From: Brereton, Steven [Steven.Brereton@lancashire.gov.uk]
Sent: 25 October 2012 14:12
To: Graeme Thorpe
Subject: RE: RE - 3/2012/0402/P & 3/2012/0539/P
Attachments: 09-10-12 Inspector's report of PI.pdf

Regarding the application for 3, 50kw wind turbines at Carr Hall Garden Centre, Whalley Road, Wilpshire (application nr 3/2012/0539) I make the following comments:

9 PHOTOMONTAGES

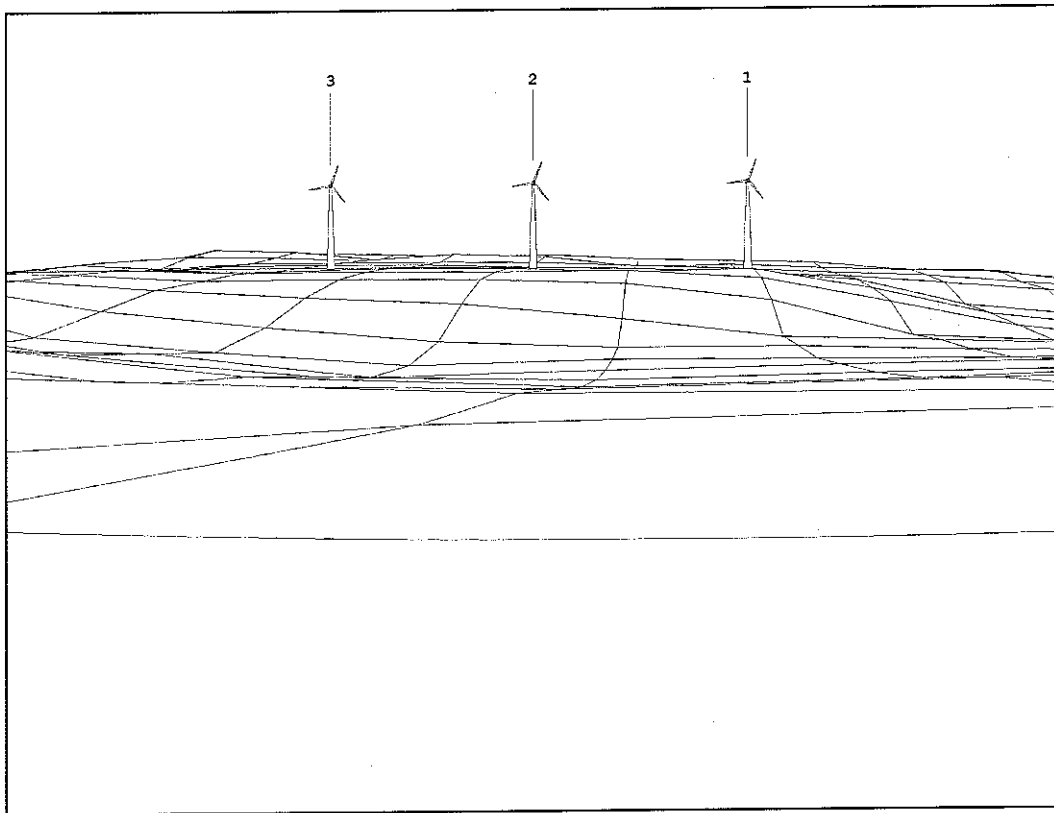
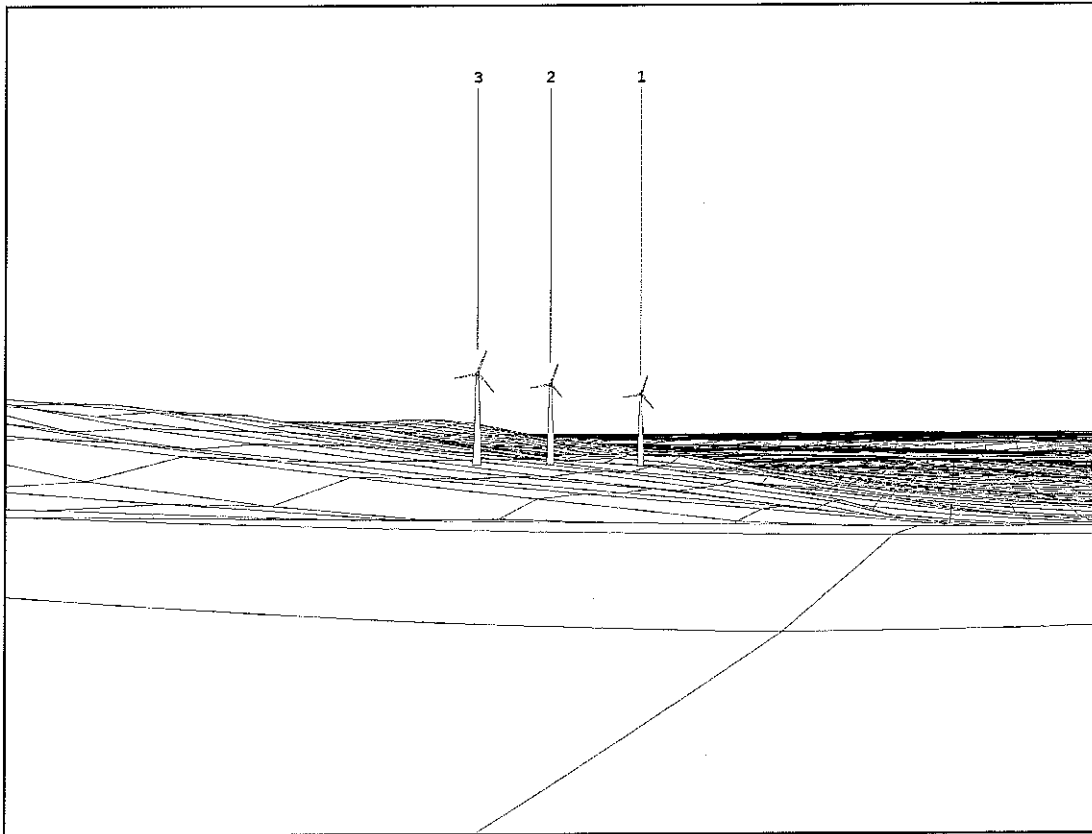
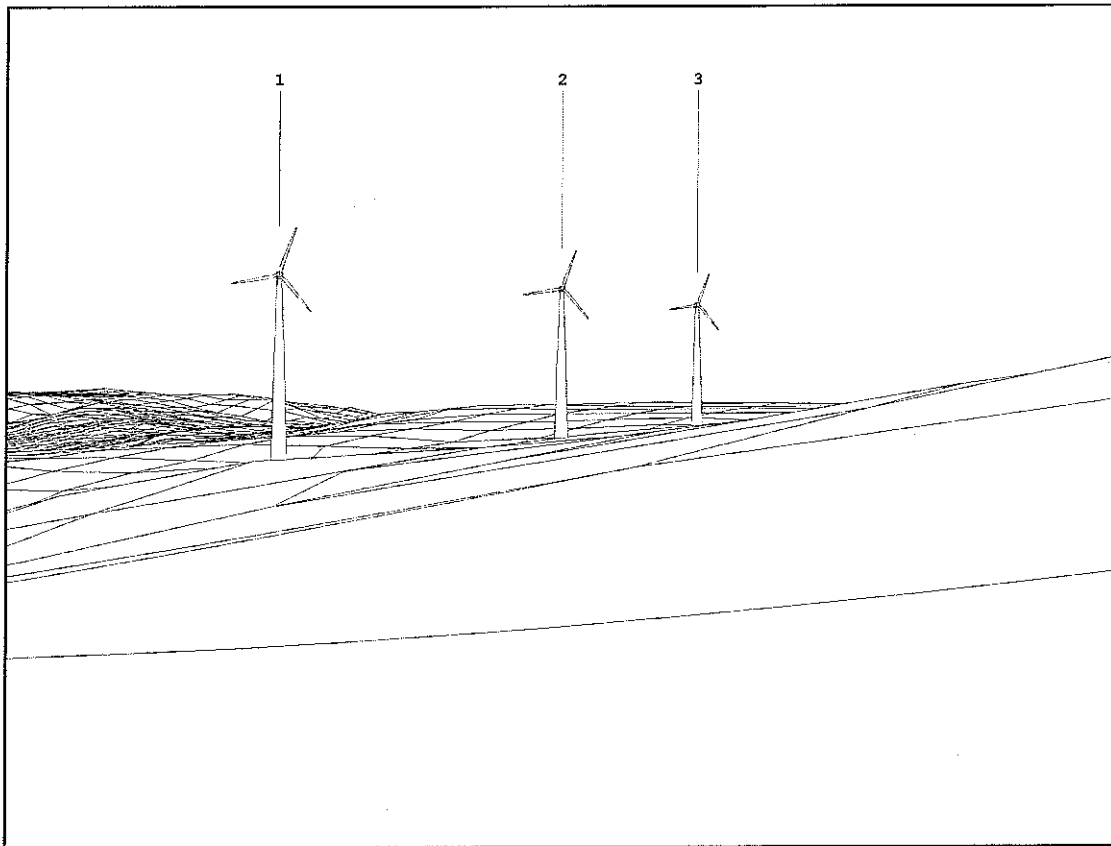
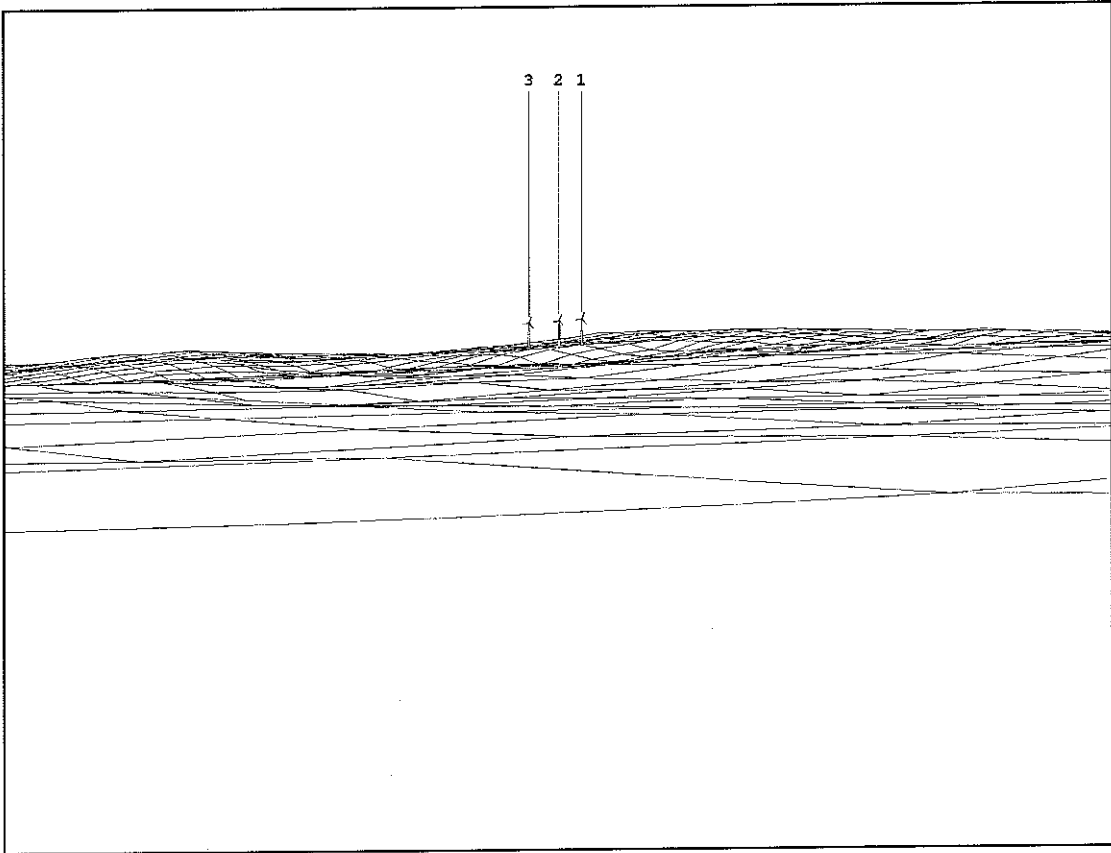
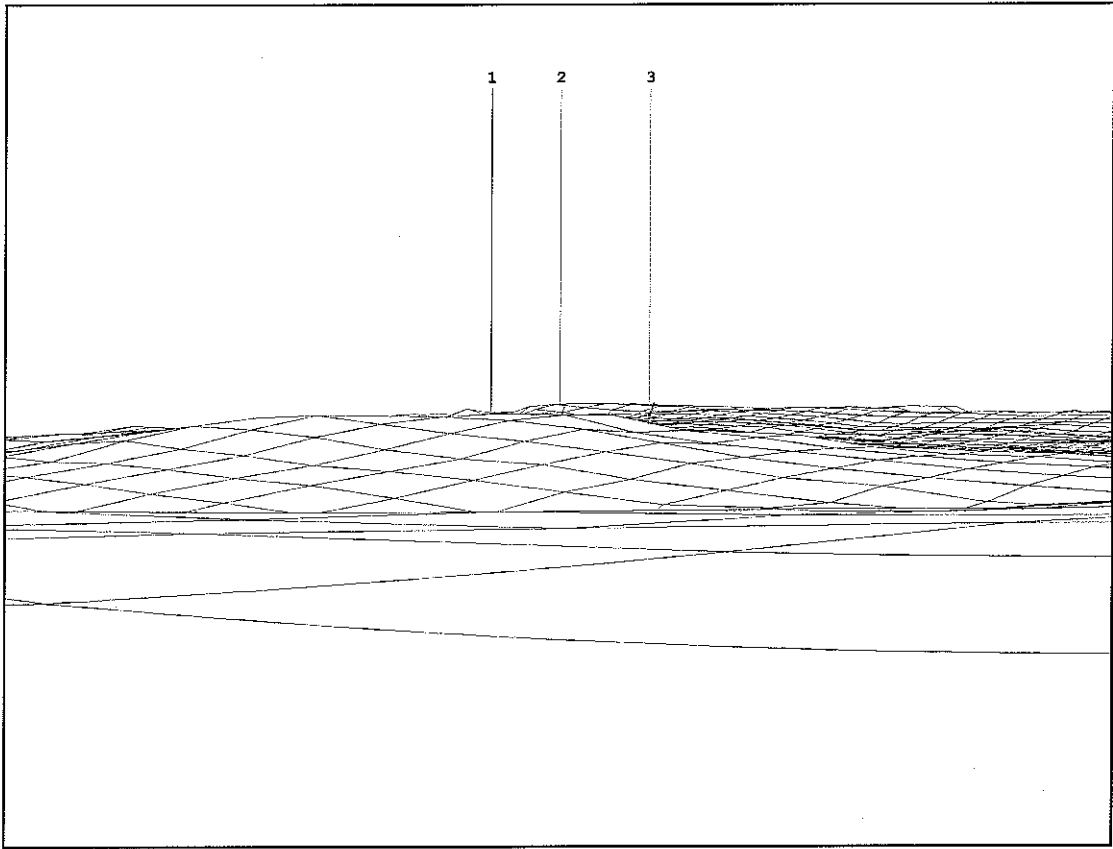
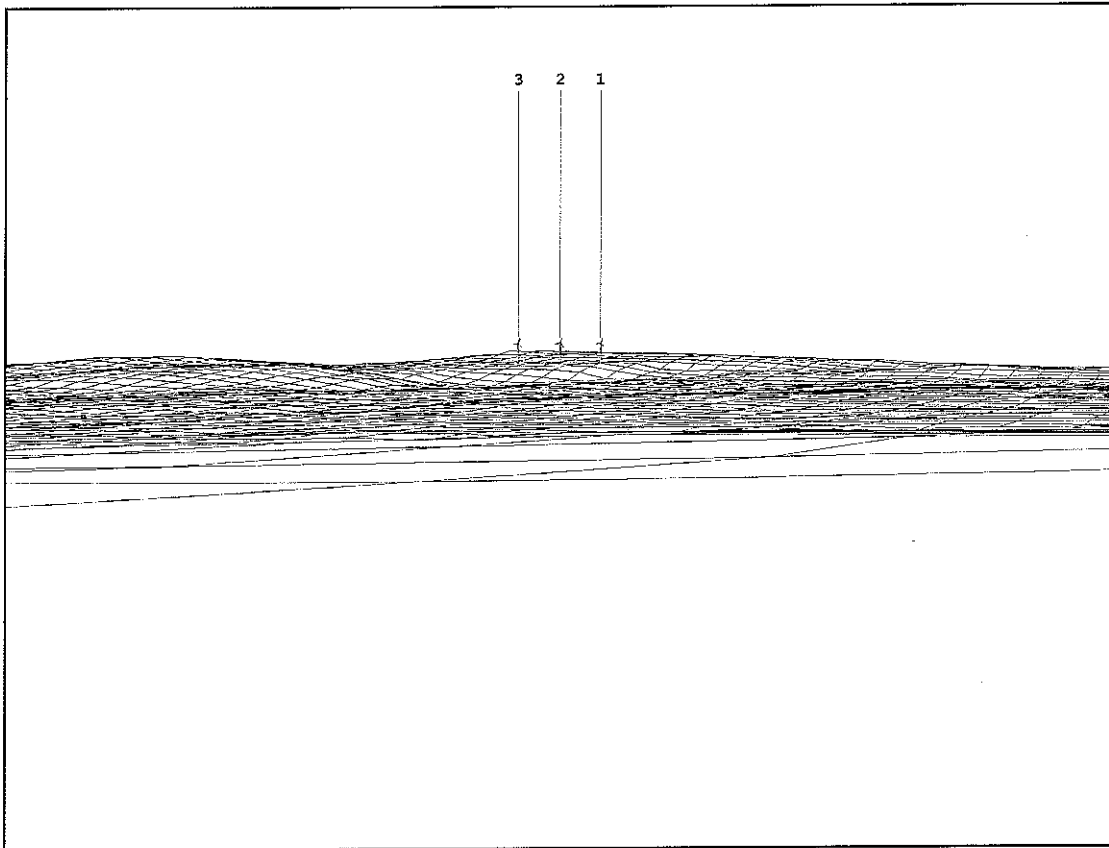
- the submitted photomontages are not acceptable and appear not to have been produced in accordance with current good practice guidance.
- no ZTV mapping – essential for a development of this size irrespective of its location – has been provided.
